Date: 16-May-2023  
Our Ref: 2023/91167

**Application for a non-material amendment following a grant of planning permission,  
Town and Country Planning Act 1990**

**Non material amendment to previous permission 2022/91990 for erection of  
extensions and alterations  
14, Thornhill Park Avenue, Thornhill, Dewsbury, WF12 0DA  
Application Number: 2023/91167**

**PROPOSAL  
PROPOSED REAR EXTENSIONS**

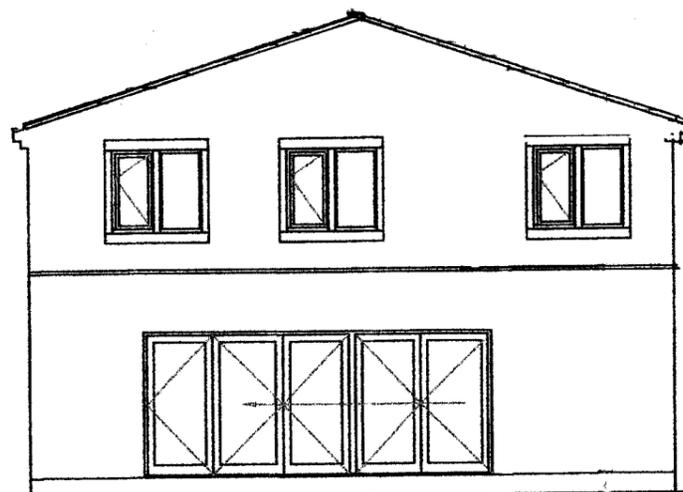
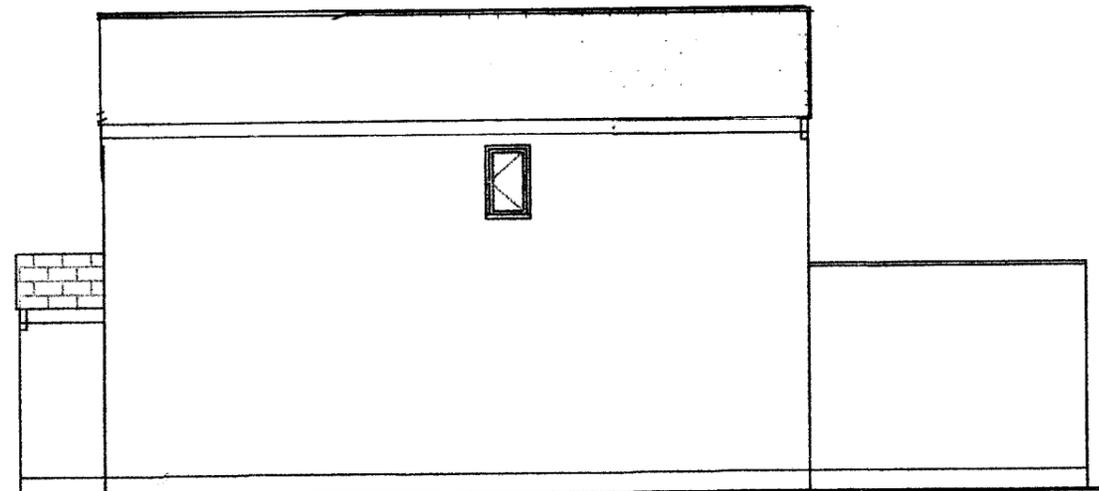
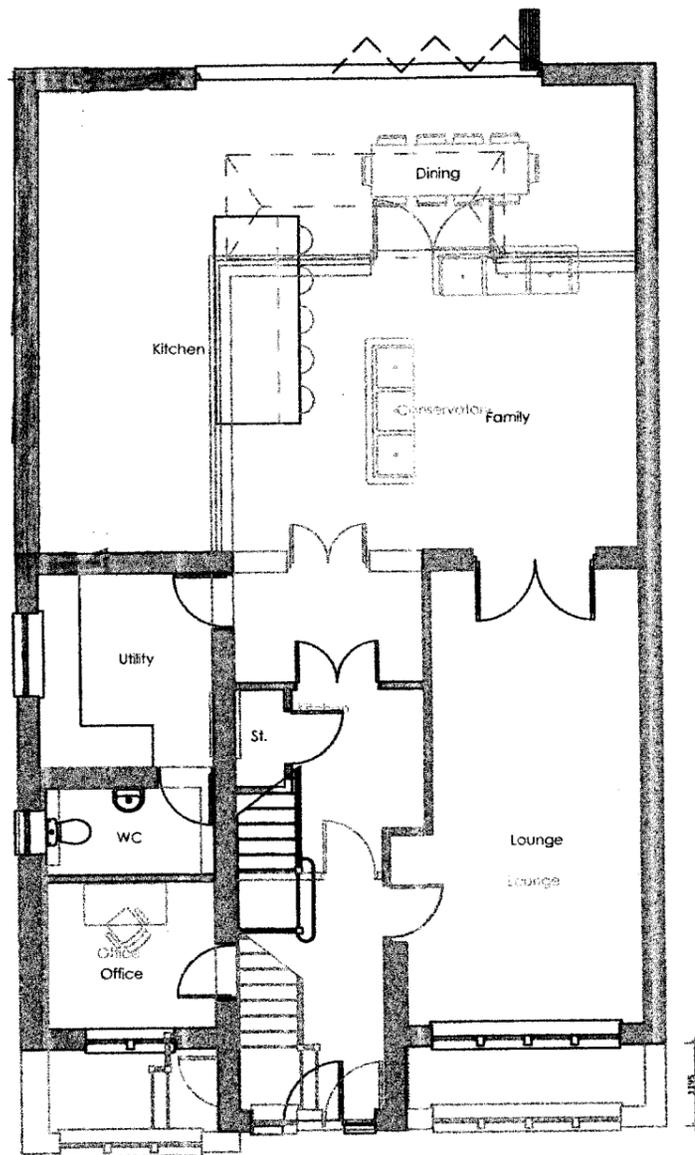
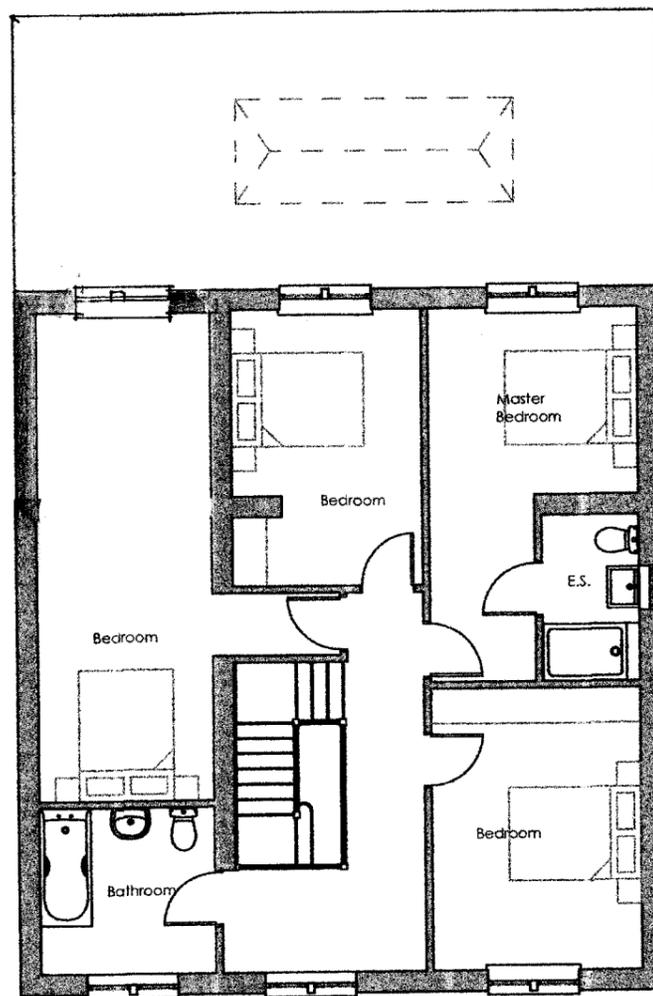
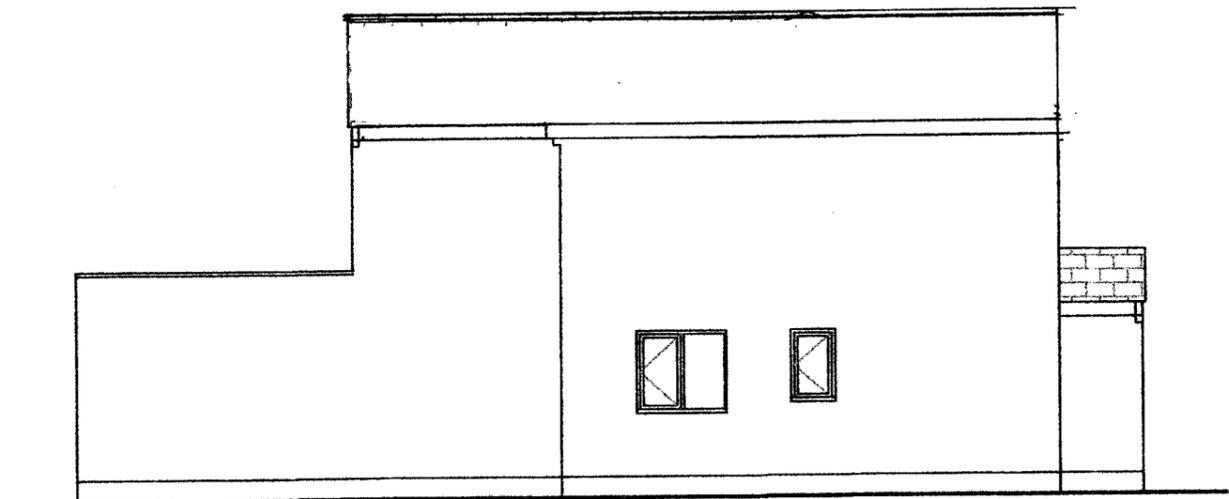
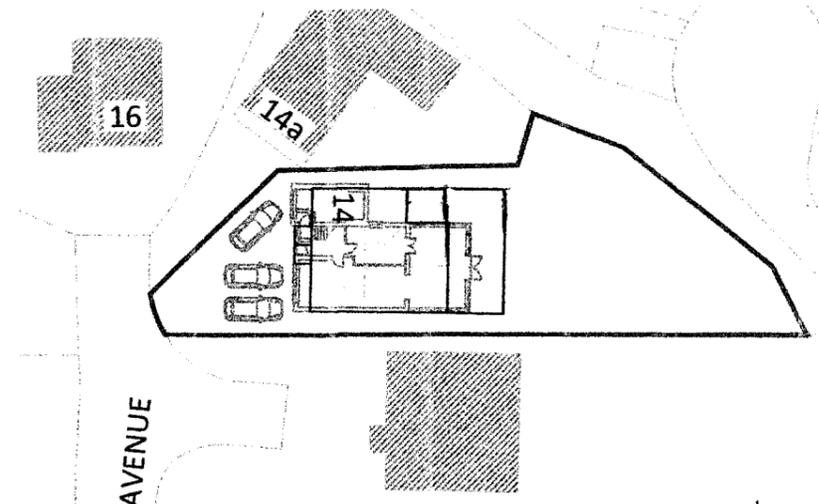
My initial comments on the scheme are: the proposed amendment would significantly increase the scale of the approved dwelling and would be contrary to policy LP24(c) which requires extensions to be in keeping with the existing building in terms of scale. It is unlikely the LPA would be able to support the amendments if they were to be submitted as a full application, particularly given the previous negotiations on application at this site.
